- 1.1 This document sets out the design office response to a Road Safety Audit (RSA) Stage 1 undertaken by Mott MacDonald in relation to a Toucan crossing on Howes Lane in relation to Axis J9 Phase 3 proposals. The full RSA report is attached as **Appendix A**.

Howes Lane, Bicester

Road Safety Audit
Stage 1

23 March 2022

JOB TITLE		ALBION LAND	
DRAWING TITLE		HOWES LANE CROSSING	
SCALE	DRAWN BY	DATE	DRAWING No
1:125@A1	RM	08/03/22	14042-60-CY
REVISION			M

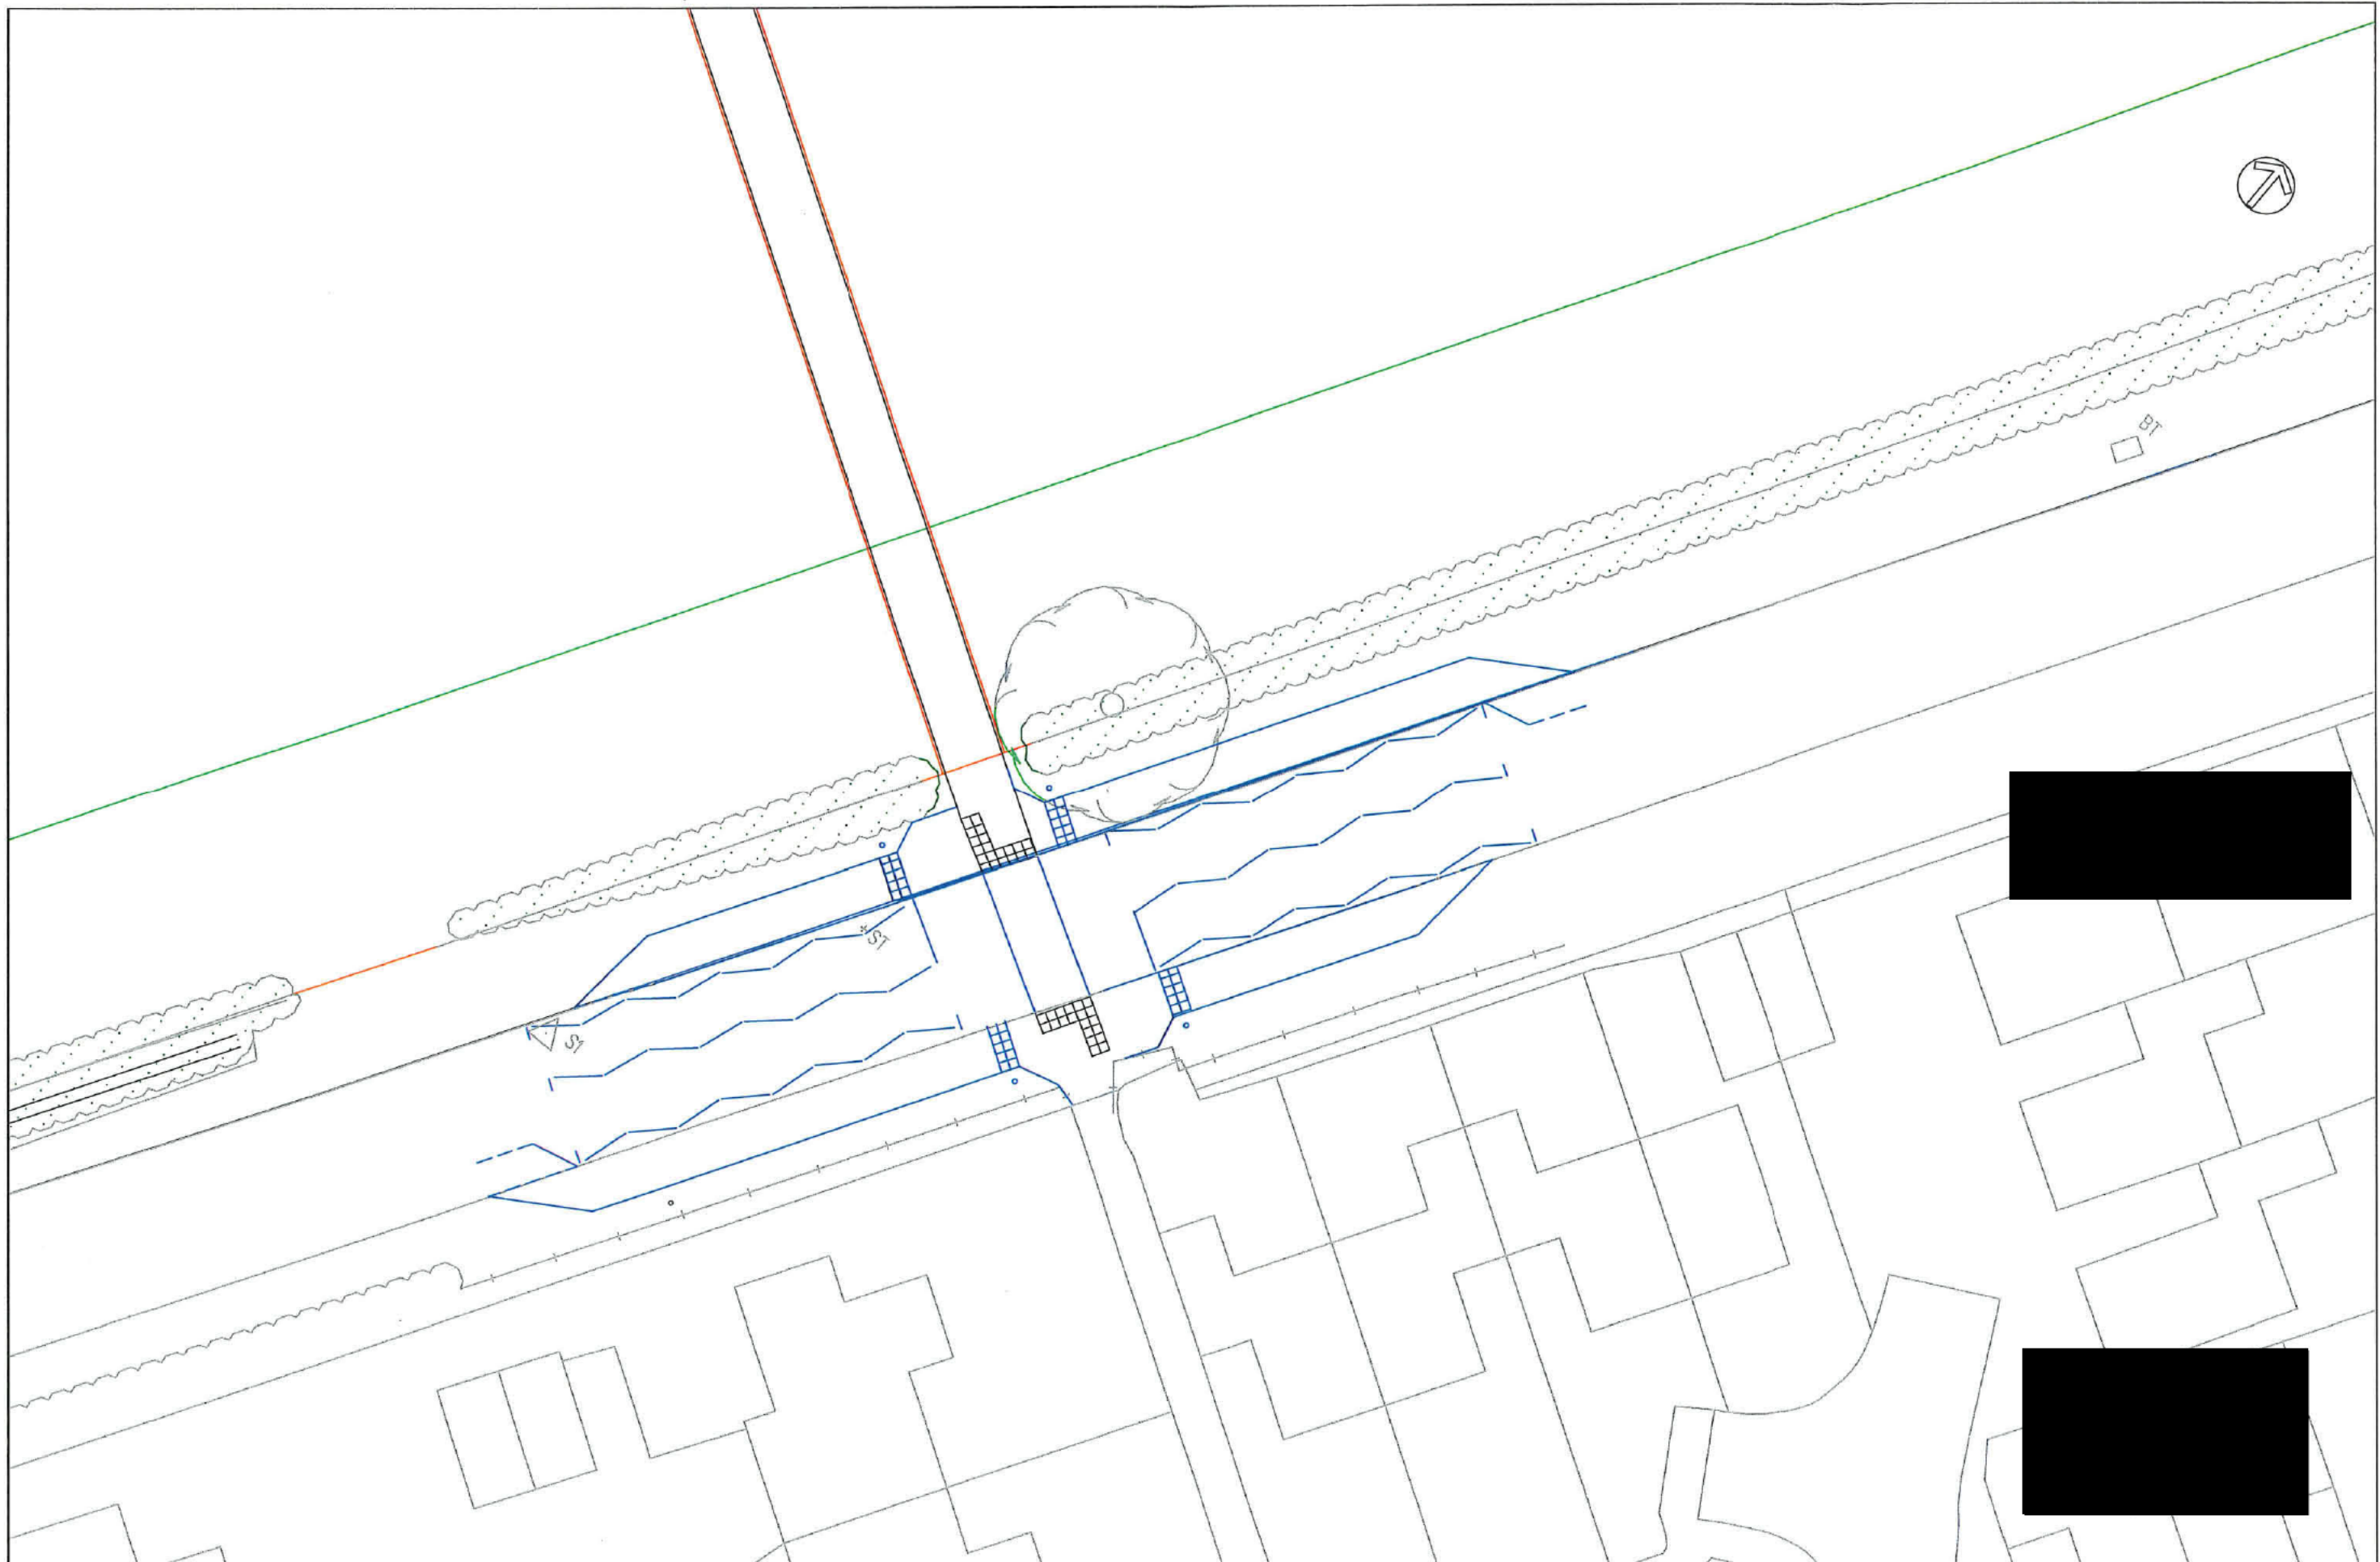
Summary: Crossing facility in line with NMU approach may lead to conflicts

It is recommended that either the Toucan Crossing is 'offset' from the footway / cycleway approaches on both sides of the Howes Lane, or a guardrail 'chicane' is installed on the new footway / cycleway on the western side of Howes Lane. The existing 'chicane' on the eastern side should be retained.

Summary: Lack of lighting provision

It is recommended that appropriate levels of street lighting are provided at the Toucan Crossing.

The proposed Toucan Crossing is shown 'in line' with the existing footway link to Wansbeck Drive and the proposed footway / cycleway into the development. As such, pedestrians or cyclists approaching the crossing facility may do so at inappropriate speed increasing the likelihood of NMUs failing to stop before entering the carriageway. This may increase the risk of collisions with approaching vehicles. A guardrail 'chicane' is present at the western end of the existing footway link to Wansbeck Drive to mitigate against this, but a similar arrangement is not proposed on the new footway / cycleway.

It is recommended that either the Toucan Crossing is 'offset' from the footway / cycleway approaches on both sides of the Howes Lane, or a guardrail 'chicane' is installed on the new footway / cycleway on the western side of Howes Lane. The existing 'chicane' on the eastern side should be retained.

It is unclear whether street lighting is to be provided at the Toucan Crossing. A lack of street lighting may result in approaching motorists failing to observe a pedestrian / cyclist waiting to, or starting to, cross the carriageway. This may lead to an increased risk of collisions between crossing pedestrians / cyclists and approaching vehicles. This may be exacerbated by approaching motorists focussing on the traffic signals rather than pedestrians / cyclists who might cross contrary to the red crossing indicator.

It is recommended that appropriate levels of street lighting are provided at the Toucan Crossing.

This recommendation is accepted and the recommendation to introduce a guardrail chicane on the new footway / cycleway on the western side of Howes Lane would be addressed at the detailed design stage.

This recommendation is accepted and would be address through the detailed design as part of the S278 works.
